**Section 96A of the Town & Country Planning Act 1990 (as amended)
Town and Country Planning (Development Management Procedure) (England) Order 2015 (as amended) - Article 10**

Application for a Non-Material Amendment Following a Grant of Planning Permission

Development: The key areas for change are to reduce the structure in size by approximately 2 sq.m, build the structure using a highly insulated timber frame construction rather than brick and block and replace the large single roof lantern with two, much smaller panoroof low level skylights.

Location: Carpenters Cottage Hoe Lane Flansham PO22 8NW

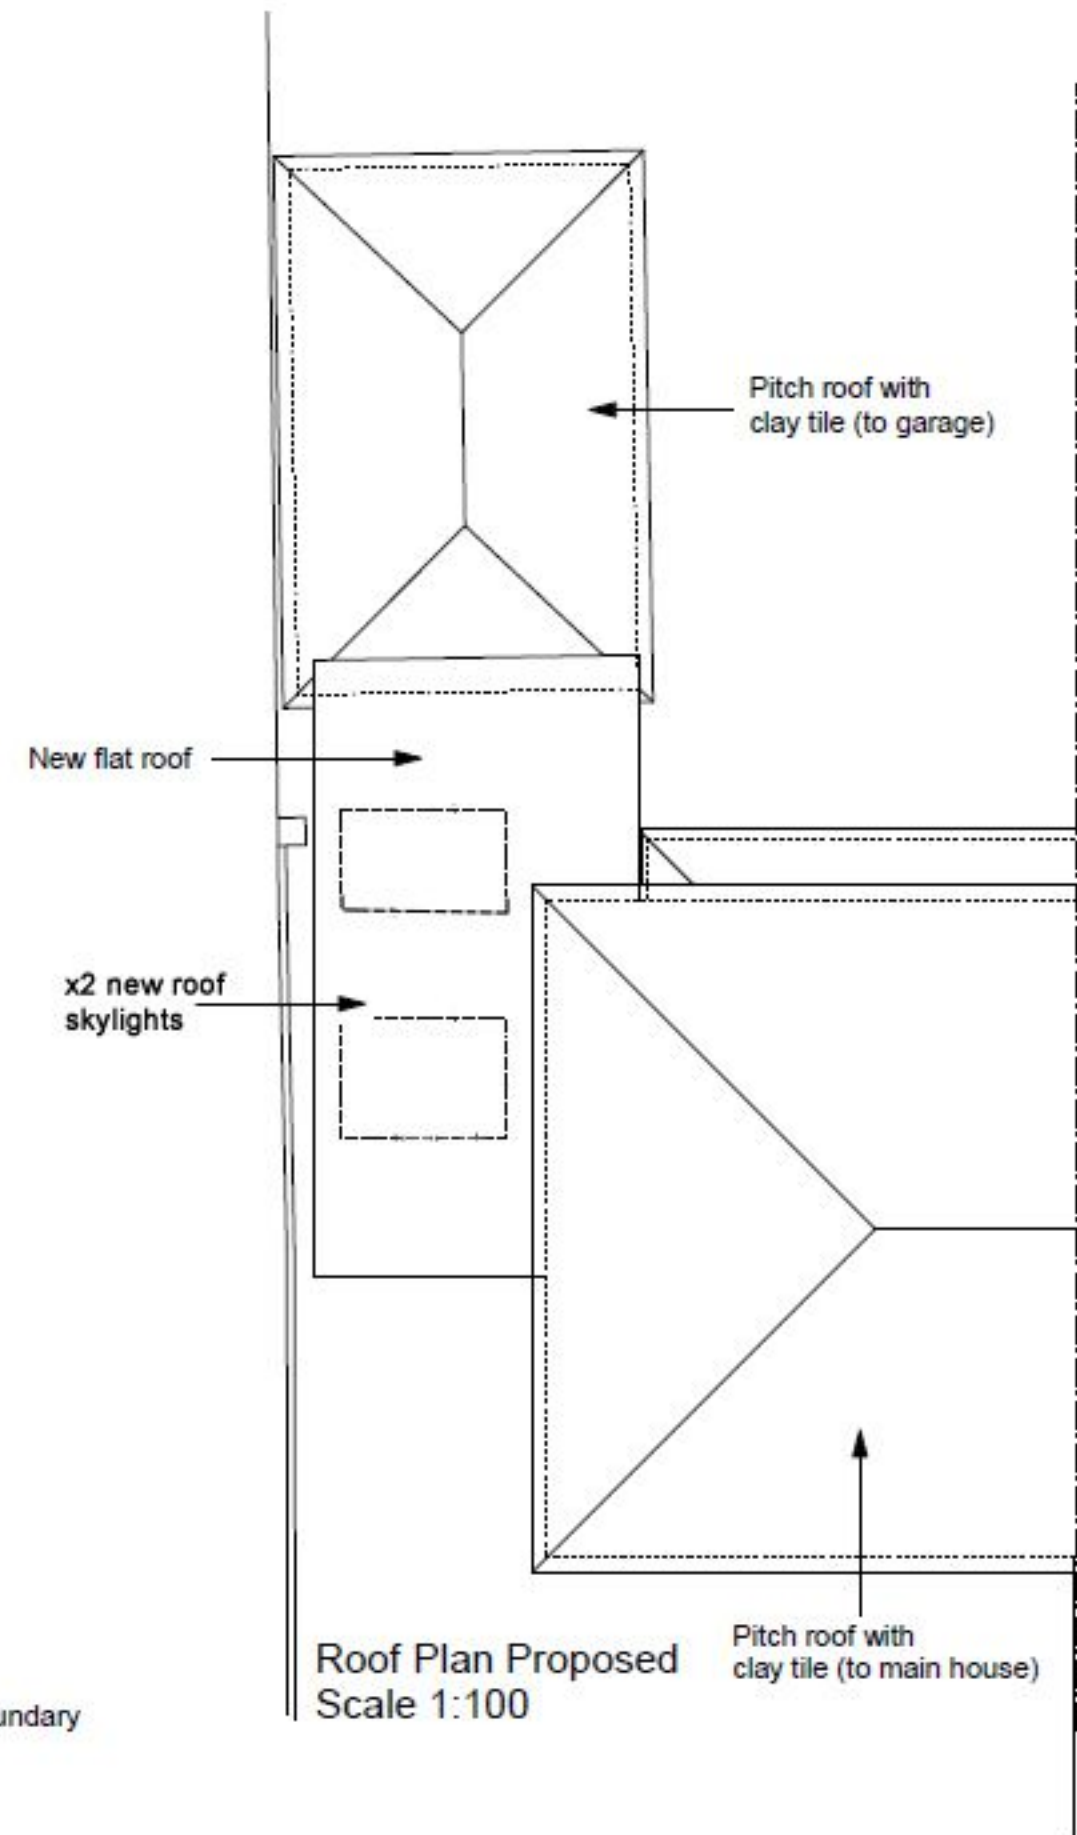
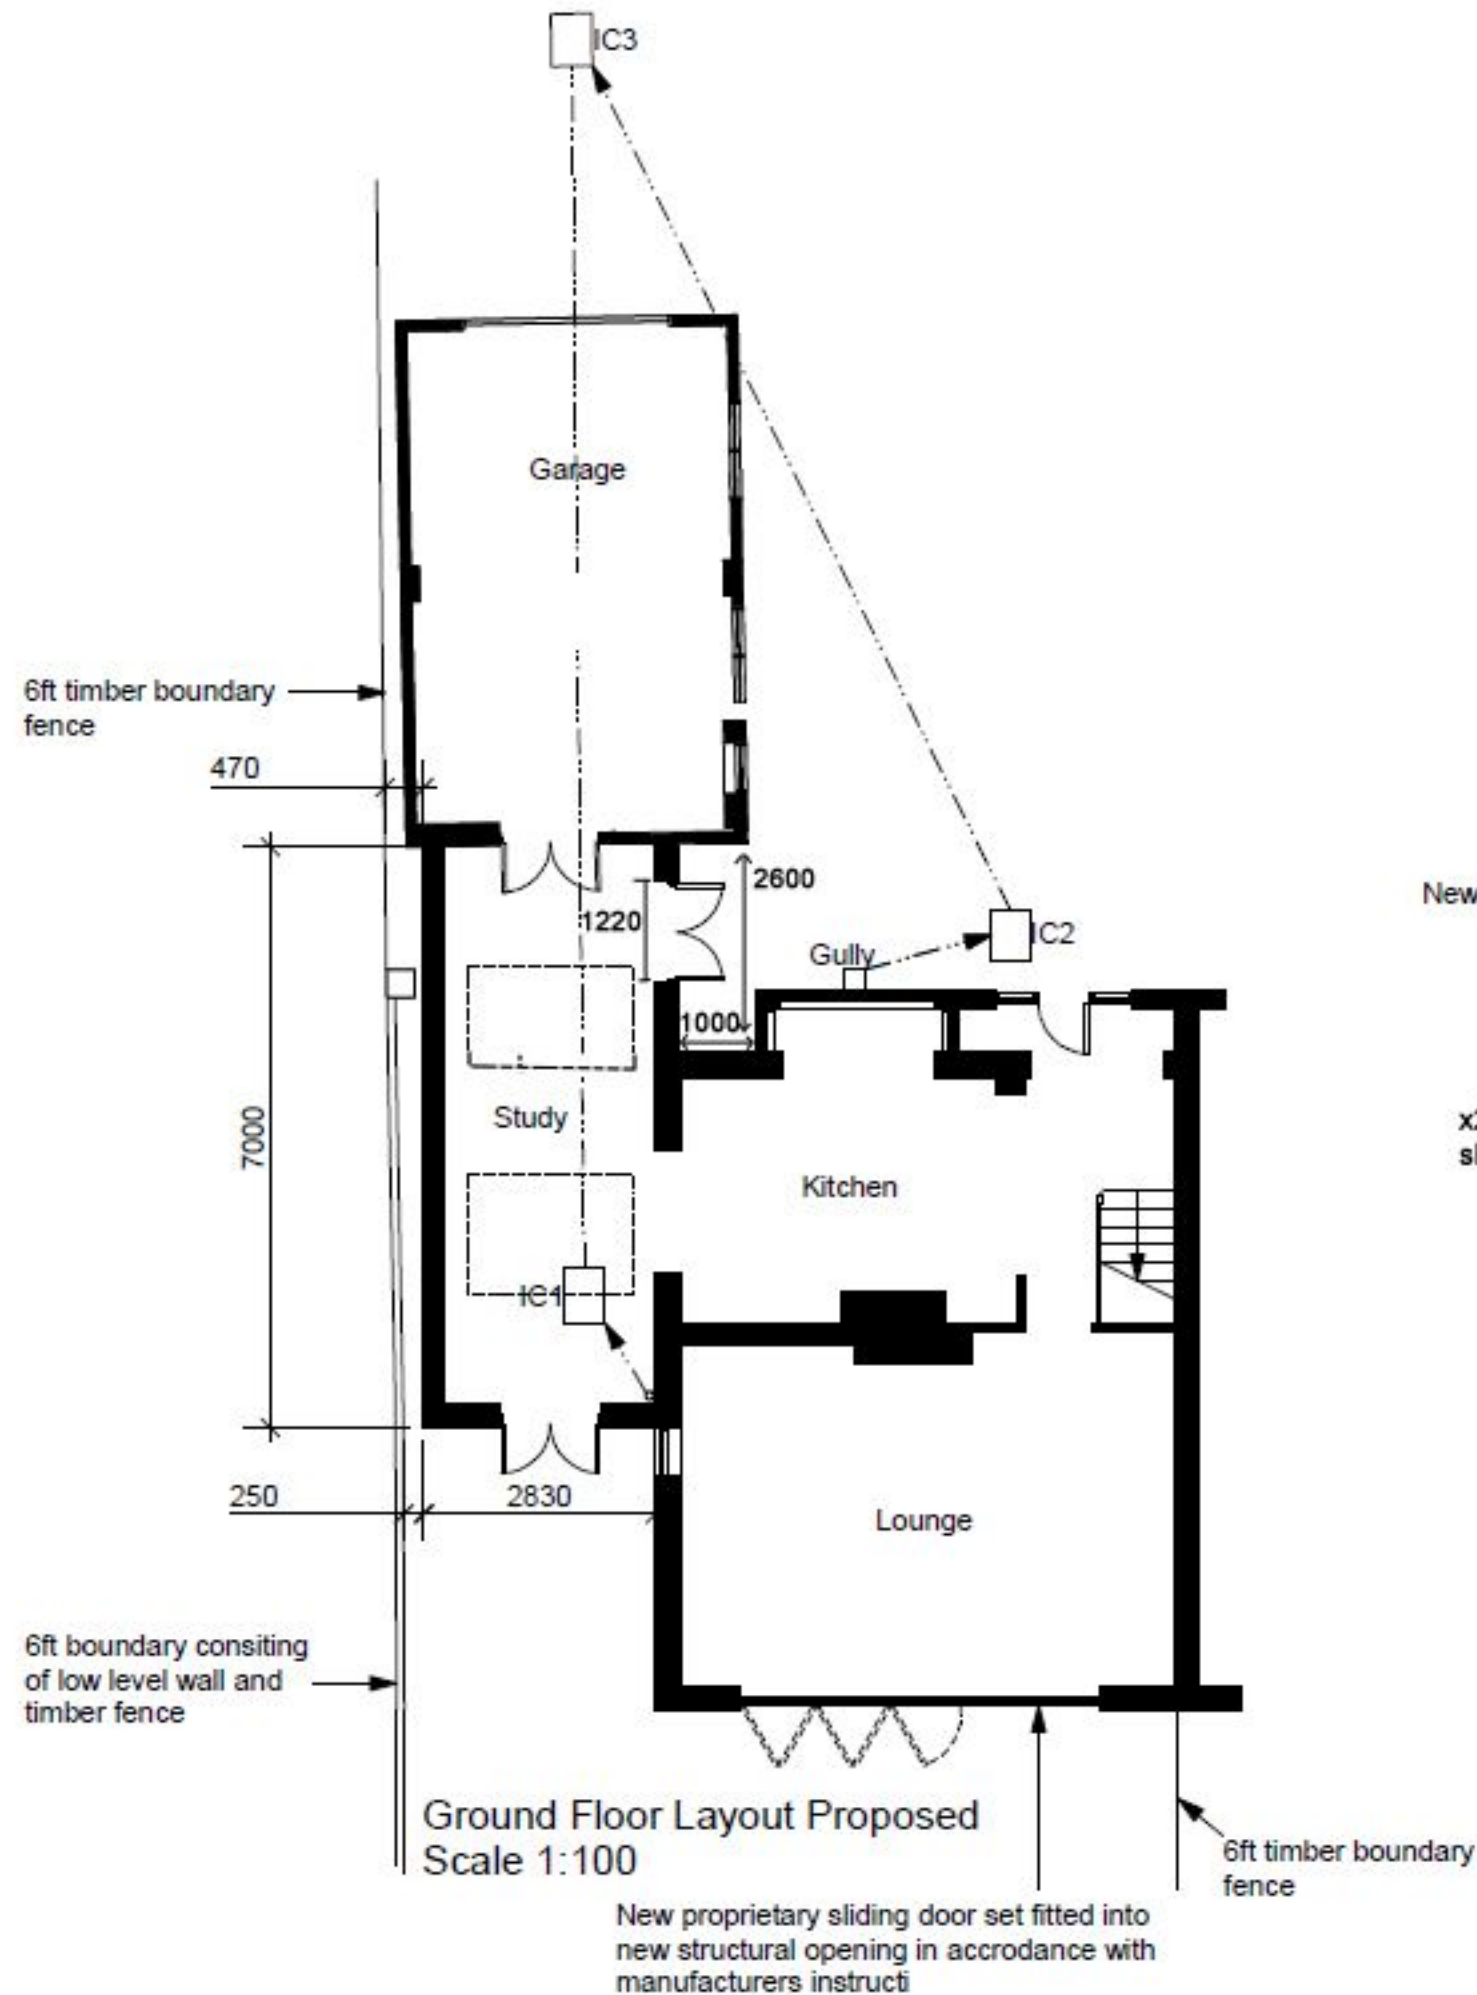
For clarity please can you show the dimension of the patio door and the floor adjustment measurements on the proposed floor Dwg No OM010.

For clarity please remove the scales from Dwg No OM010 as measurements are shown.
